CITY OF ALBUQUERQUE

RE: 5046 Valle Del Sol Rd. NW
Grading and Drainage Plan
Engineer's Stamp Date: 11/06/18
Hydrology File: J11D038

RE: 5046 Valle Del Sol Rd. NW
Grading and Drainage Plan
Engineer's Stamp Date: 09/07/18
Hydrology File: J11D038

MCDONALD - GRADING & DRAINAGE PLAN

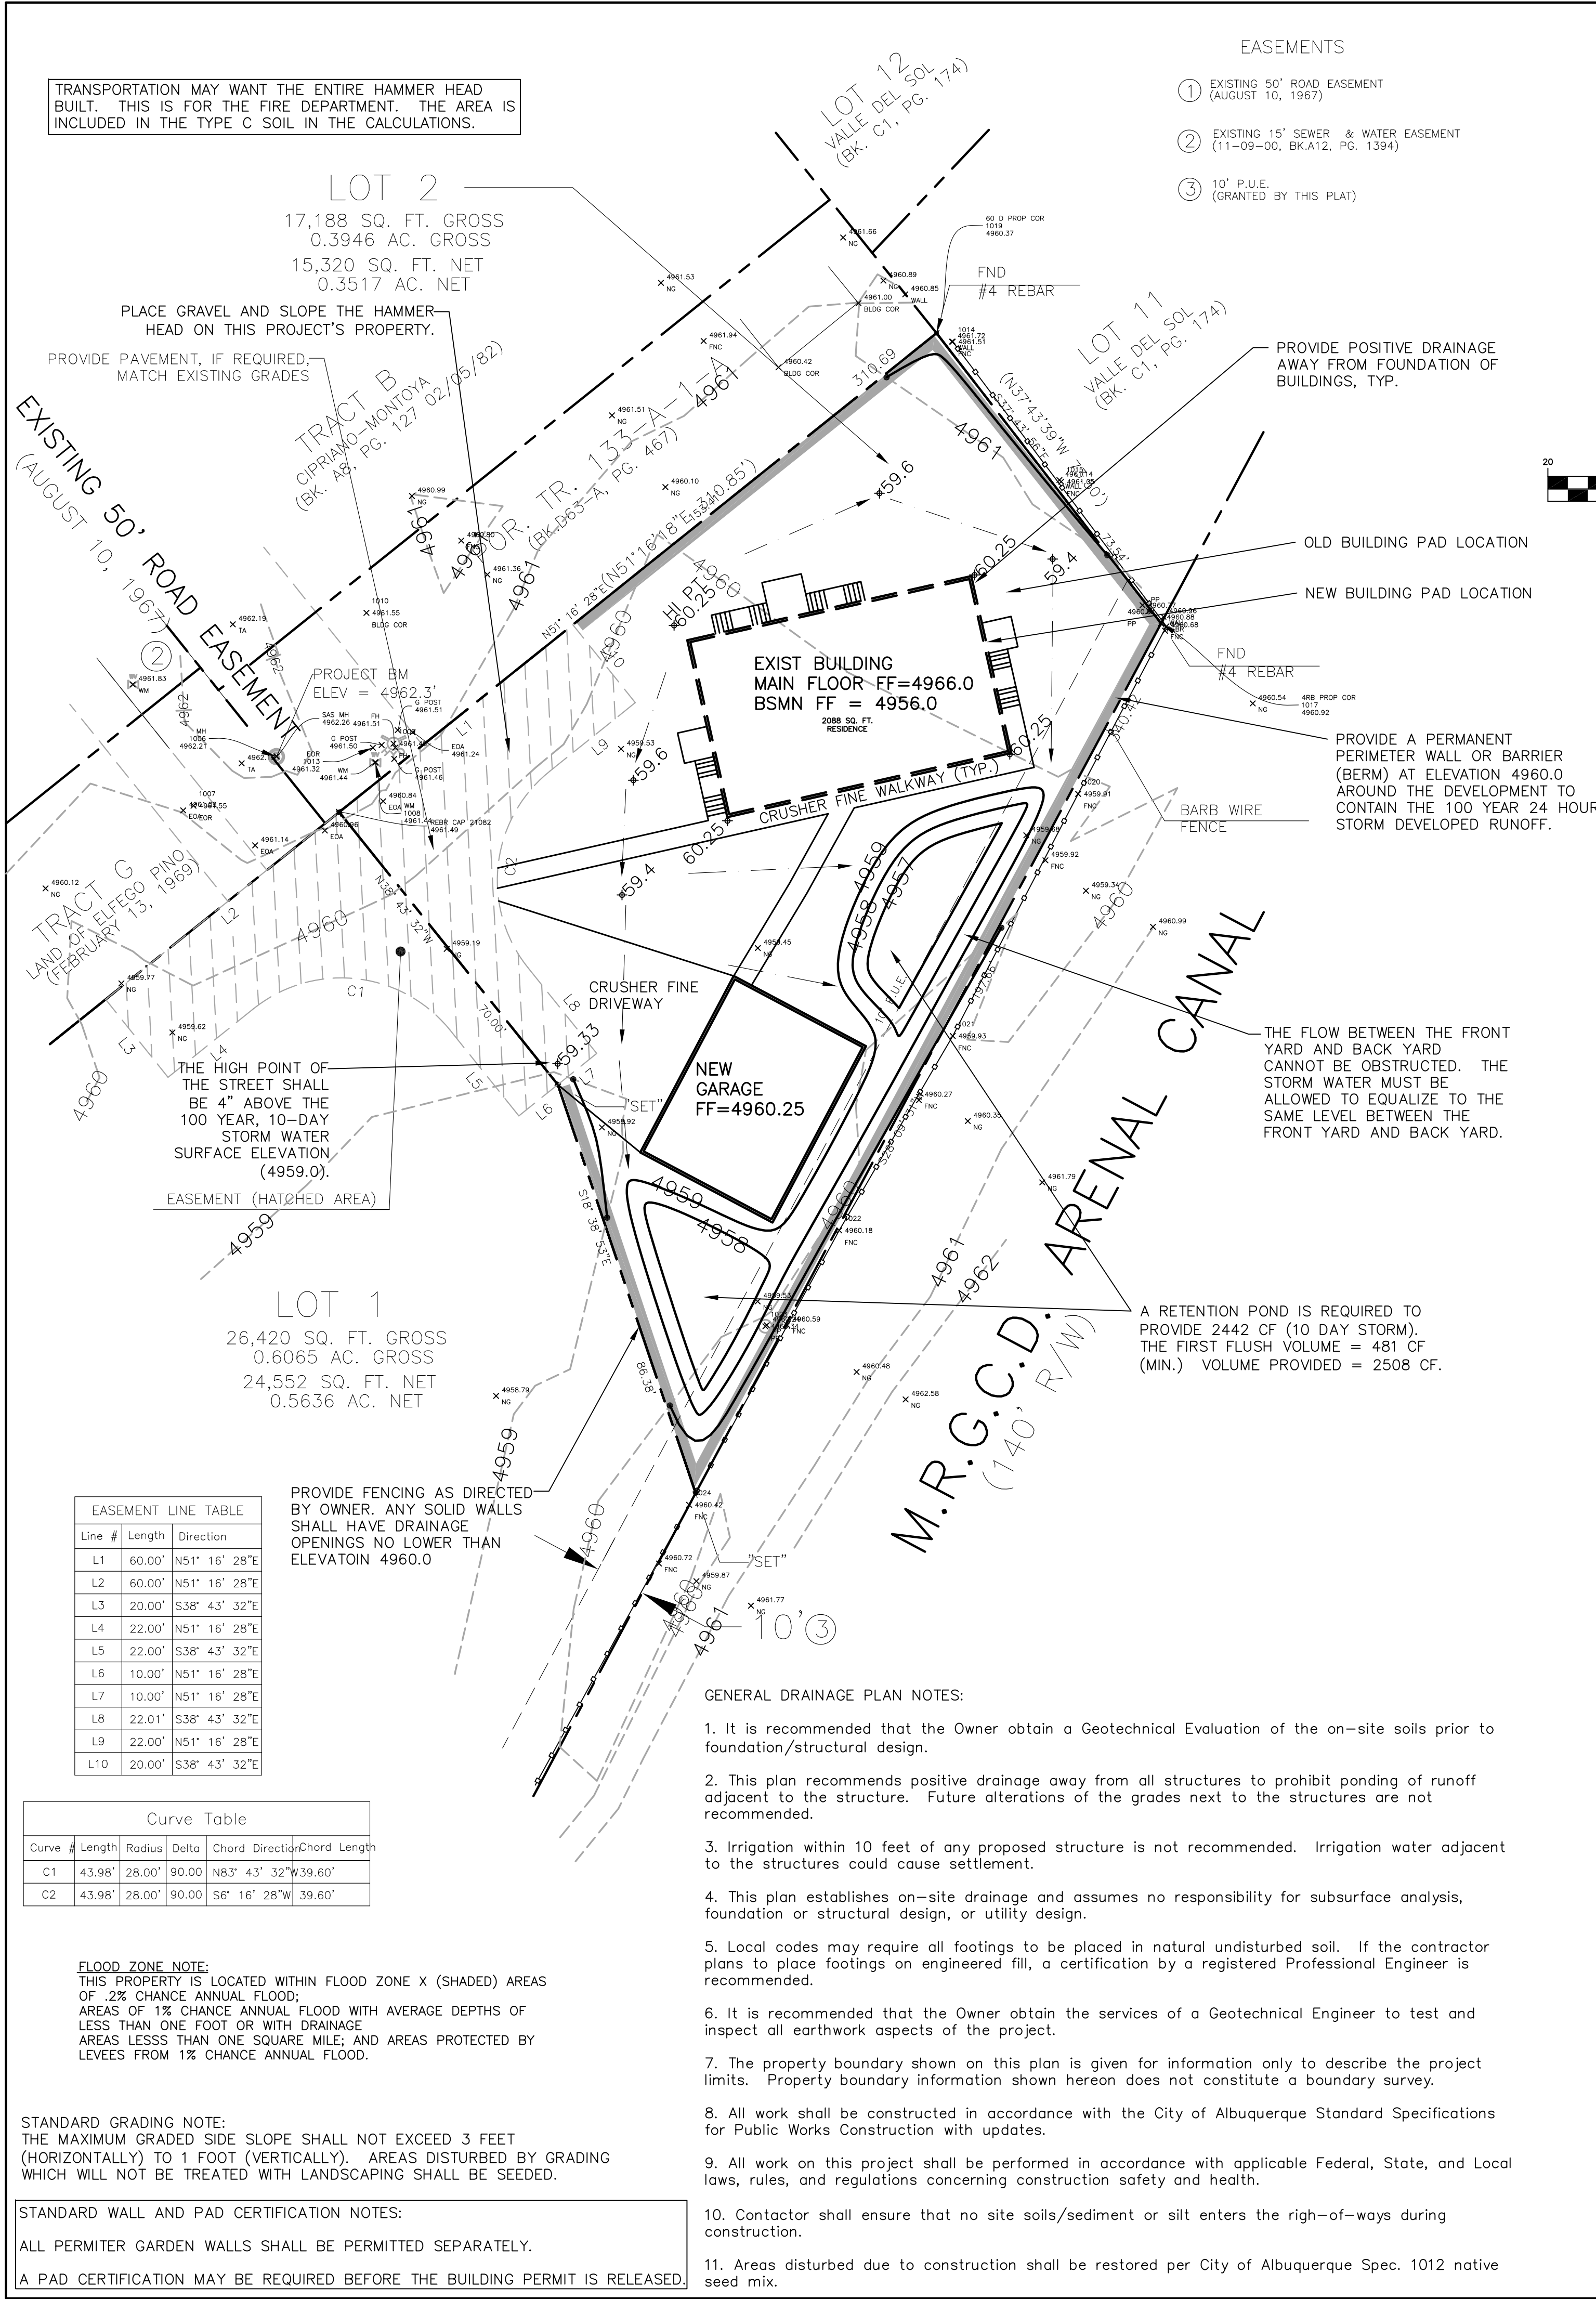
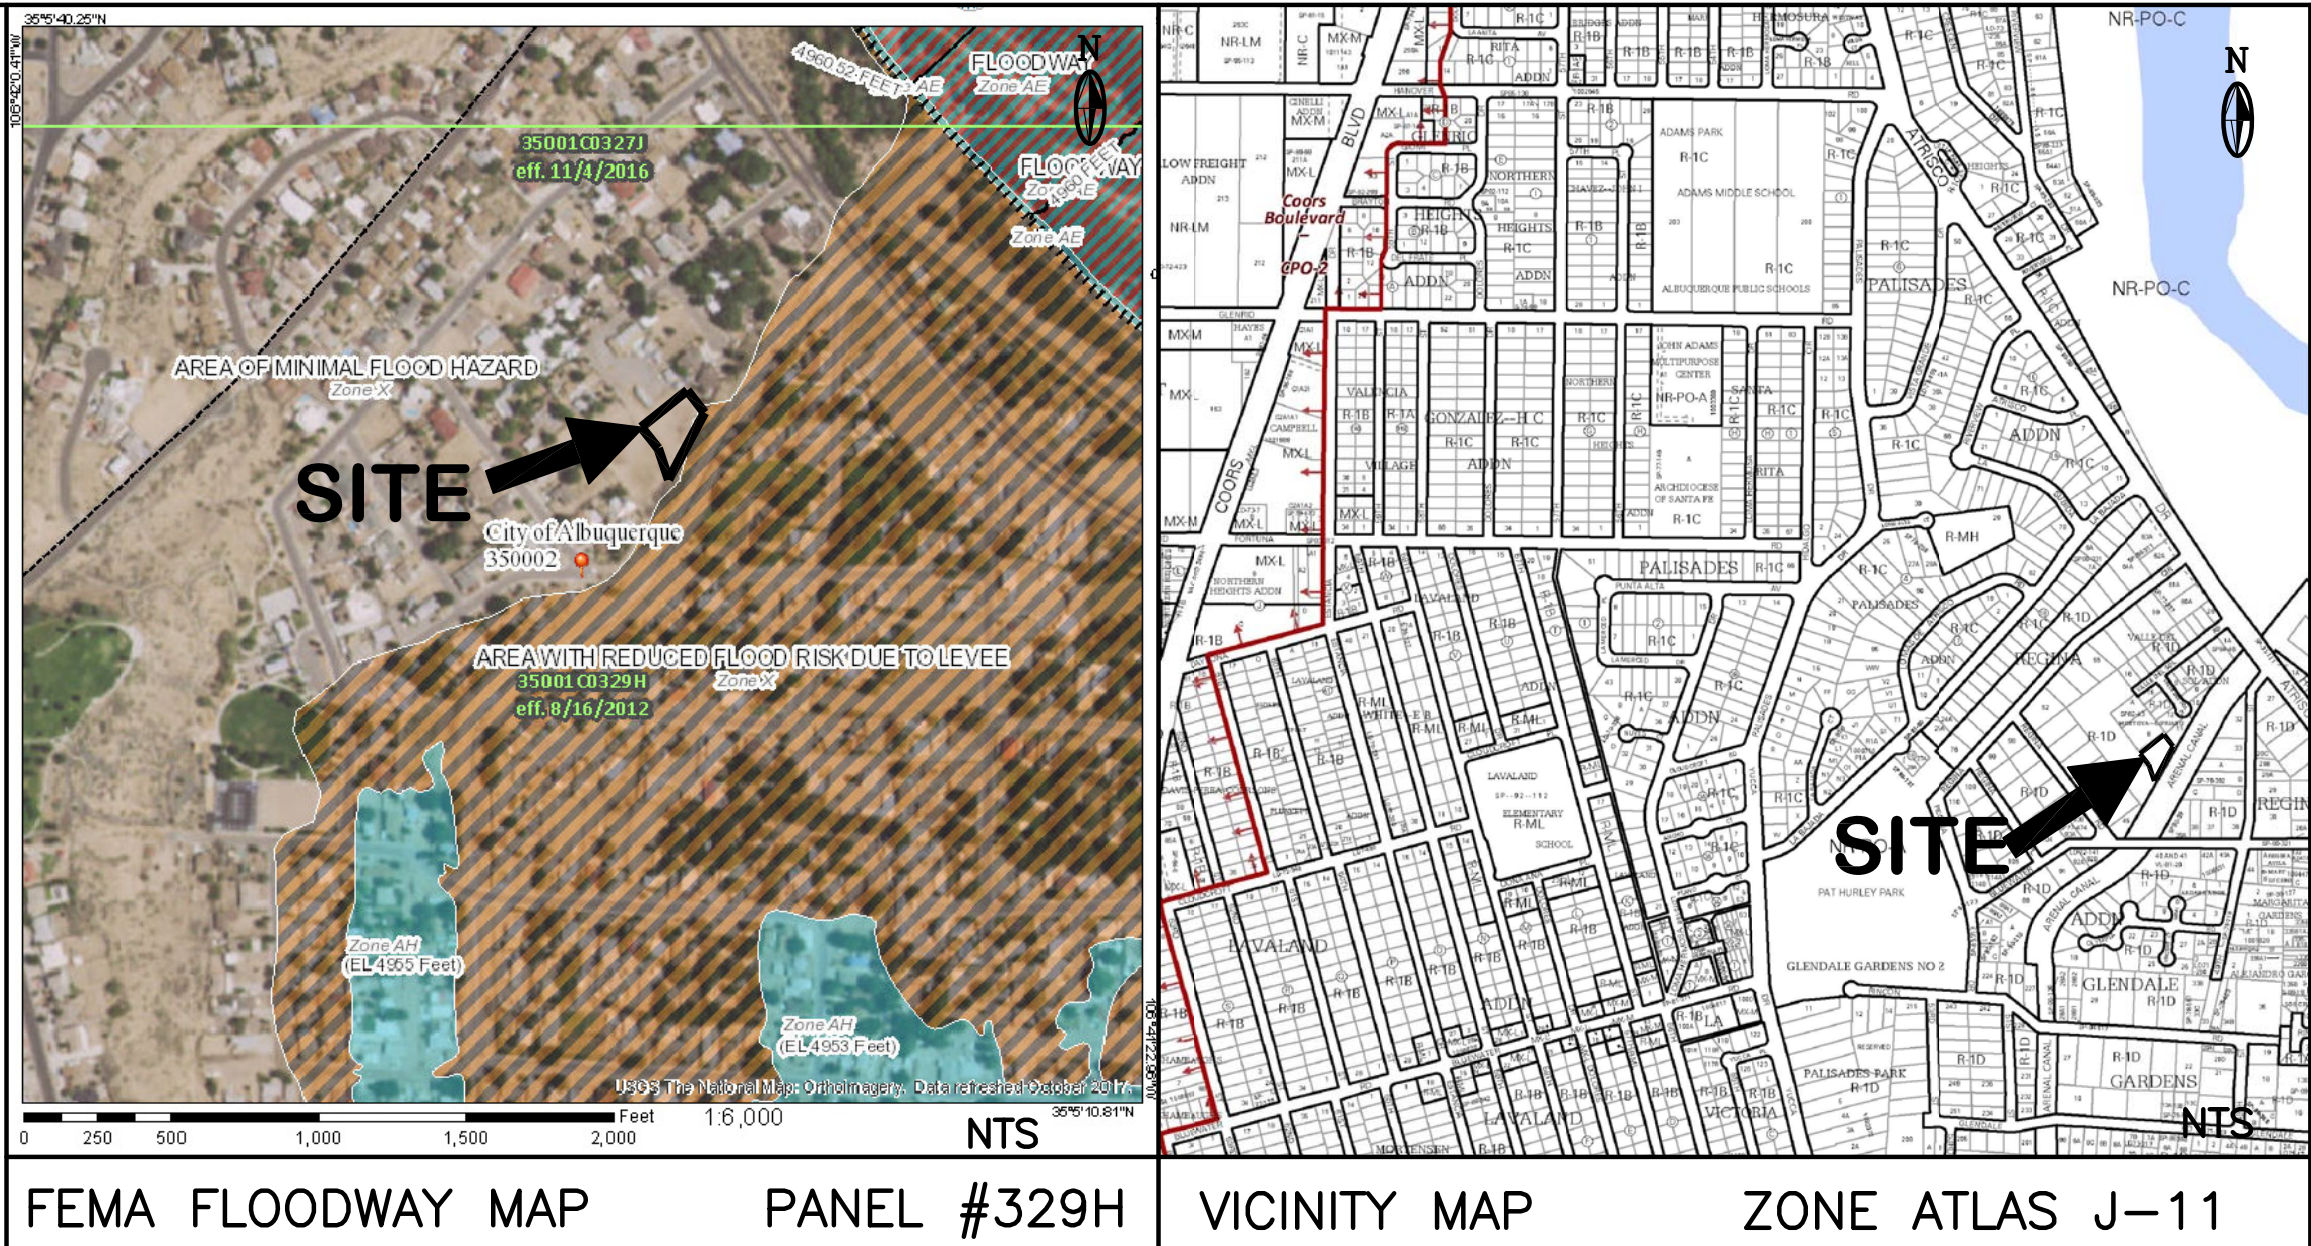
1. Currently the design does not follow the Flat Grading Scheme outlined in the DPM. Please follow Chapter 22 Section 5.G (Flat Grading Scheme). The following conditions must be applied to the site:

- a. The maximum percent impervious of the lot and the contributing area may not be greater than 45%. **The site meets this requirement.**
 - b. Pad elevation shall be a minimum of one (1) foot above the 100 year 10-day storm water surface elevation. **The finished floor of the main level is 6 feet above existing grade and the basement is 10' below main level.**

- c. The flow between the front yard and back yard cannot be obstructed. The storm water must be allowed to equalize to the same level between the front yard and back yard. **Note has been added.**

- d. A permanent perimeter wall or barrier around the development is required to contain the 100 year 24 hour storm developed runoff. **Note has been added.**

- e. The high point of the street should be four inches above the 100 year 10-day storm water surface elevation. **Note has been added.**
2. Also a retention pond is required. The required volume = (3.67 in. X impervious area / (12in/ft)). The location with elevation of pond and the calculation of both the required and actual volume needs to be shown on the Grading Plan. **Note has been added.**

3. Please place gravel and slope the hammer head on this project's property at least. Transportation may want the entire hammer head built. This is for the Fire Department. The area of this graveled hammer head needs to be included in the Type C soil in the calculations. **Note has been added.**
